Preferred Project Report Modification to Concept Plan

Frasers Broadway
(Formerly CUB Site)

Submitted to
Department of Planning
On Behalf of Frasers Broadway Pty Ltd

October 2008 ■ 08084

SECTION THROUGH 7 GOOLD STREET AND ALONG TOOTH AVENUE

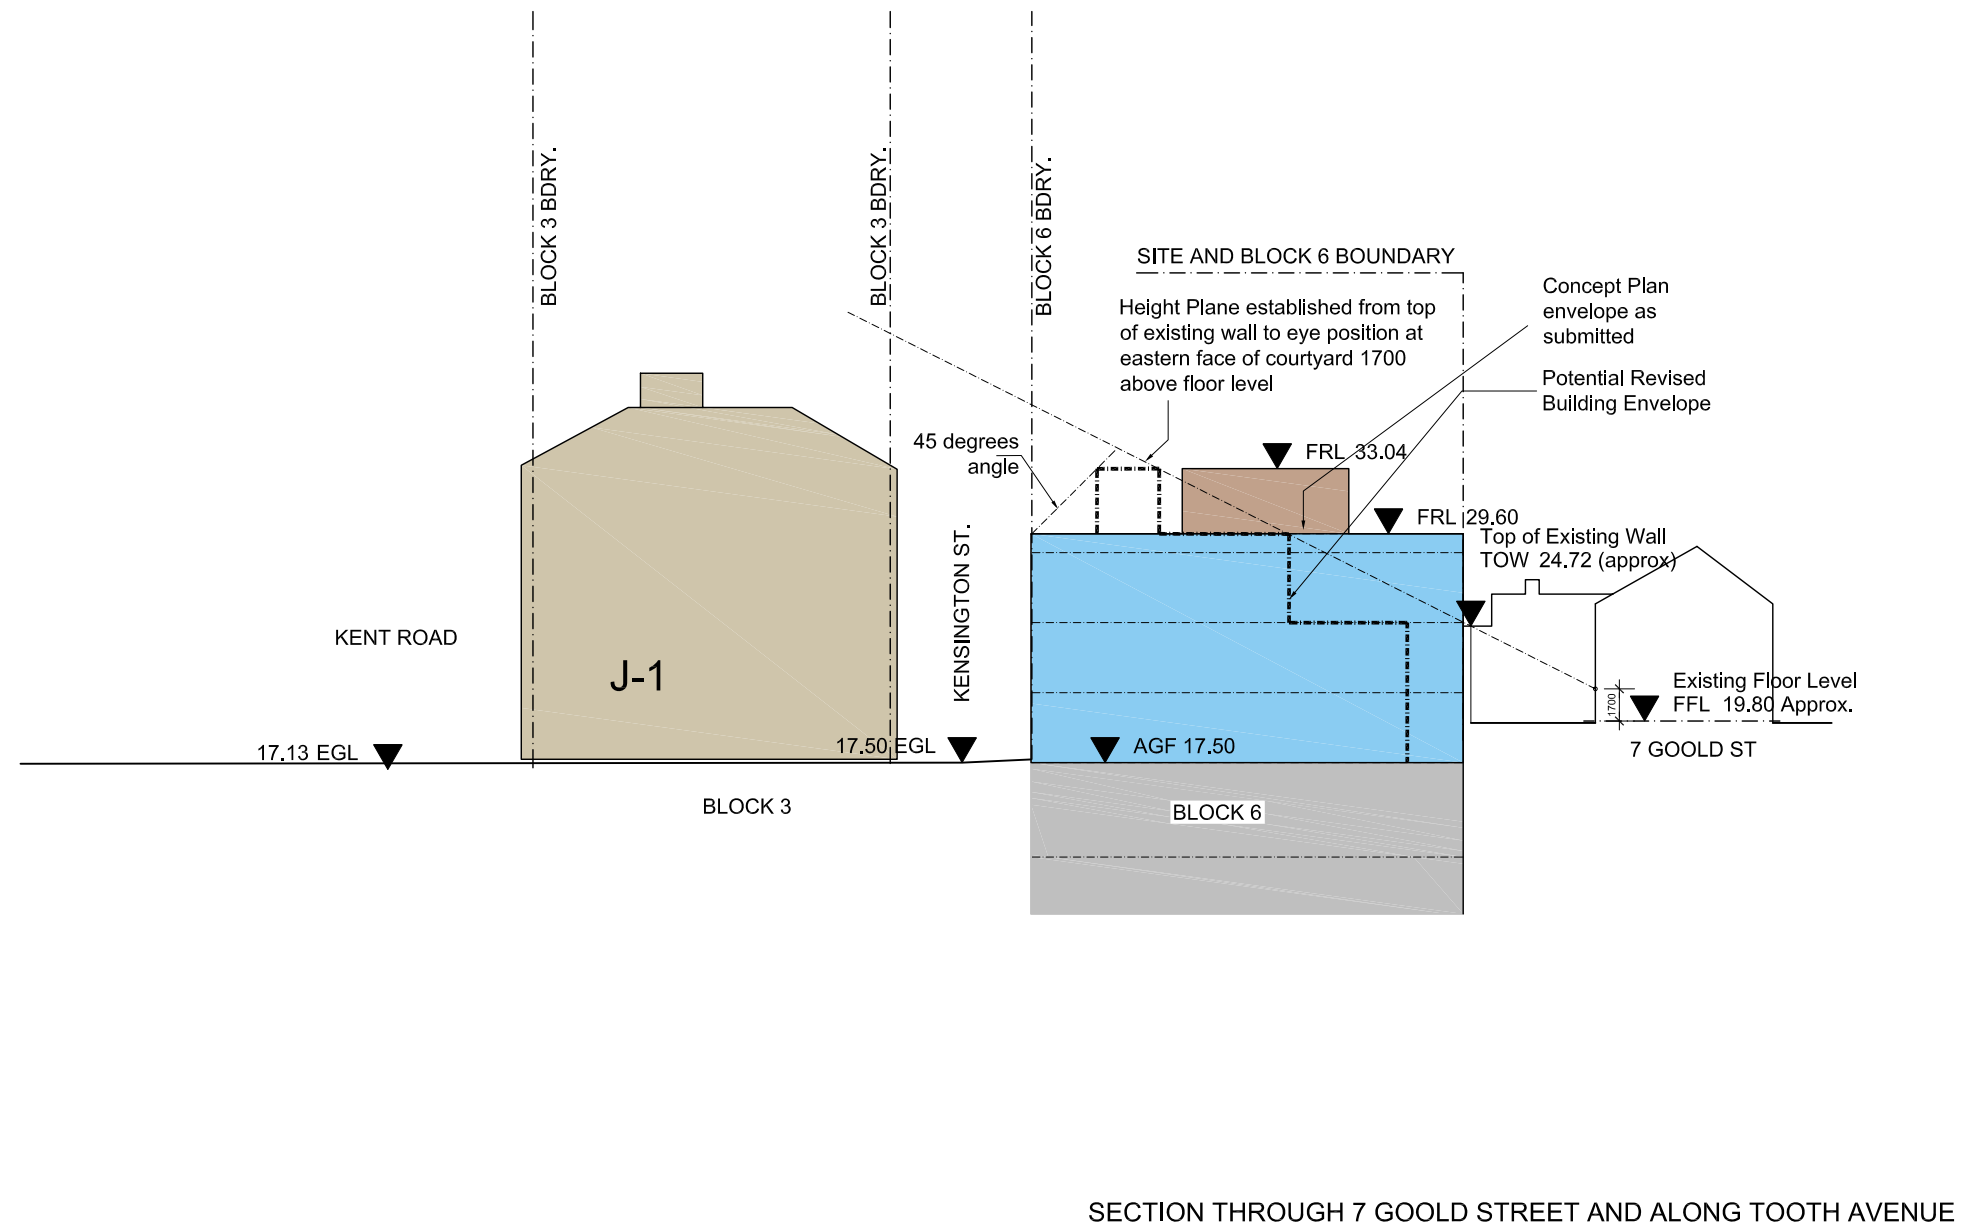
The height, bulk and scale of Block 6 should be reduced to better relate to the pattern of existing bulk/scale of heritage buildings in Kensington Street.

The height and scale of Block 6 is considered to be consistent with the surrounding built form context. Similar or higher building forms adjoin the site to the west across Kensington Street (Block 3) and to the rear on Dwyer Street. Notwithstanding this, the rear of the Block 6 building has been amended to step back from the existing 2 storey dwellings in Goold Street to maintain the height plane from the rear of the dwellings to the existing structures on the site. A cross section showing the relationship of the proposed Block 6 envelope with properties at the rear on Goold Street is shown in **Figures 10 and 11**.
